Re: Kiddie Academy Westside – 4590 Paradise Blvd. Mulberry SE
Erosion and Sediment Control Plan
Engineer's Stamp Date: 8/17/2020 (C12E004)

Based upon the information provided in your submittal received 8/17/2020, the above referenced plan can't be approved until the following comments are addressed:

Temporary Erosion and Sediment Control Plan

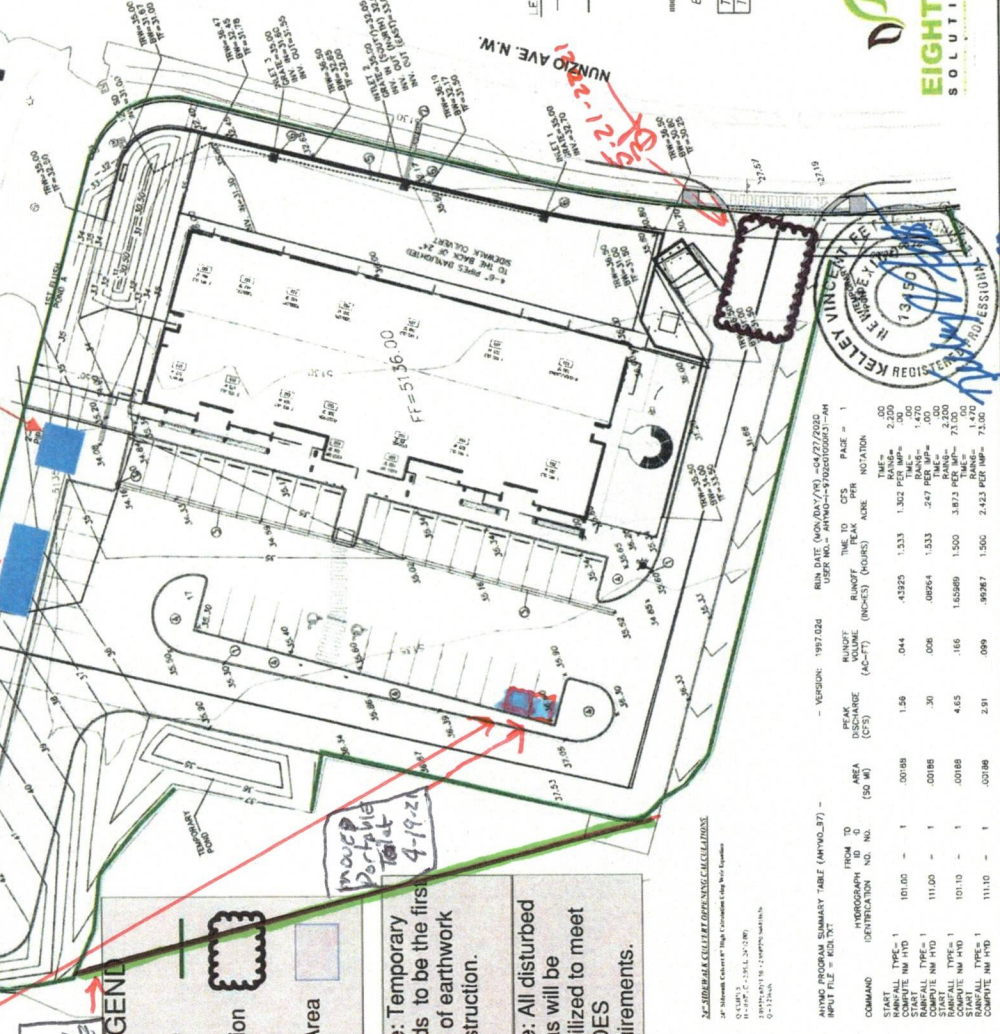
1. The construction support activity area where the contractor borrowed dirt from on lot A2B1, owned by Novus Properties, must be shown on the SWPPP map per CGP 7.2.4.b,
2. Also show the locations of stormwater controls at the borrow area, including any shared controls utilized to comply with this permit per CGP 7.2.4.i, and
3. Include the specific vegetative and/or non-vegetative practices that will be used for stabilization and the beginning and ending dates of the seasonally dry period and the schedule you will follow for initiating and completing vegetative stabilization.
4. Identify the operator(s) responsible for 2 and 3 above whether they are operators under this construction site or a separate site.
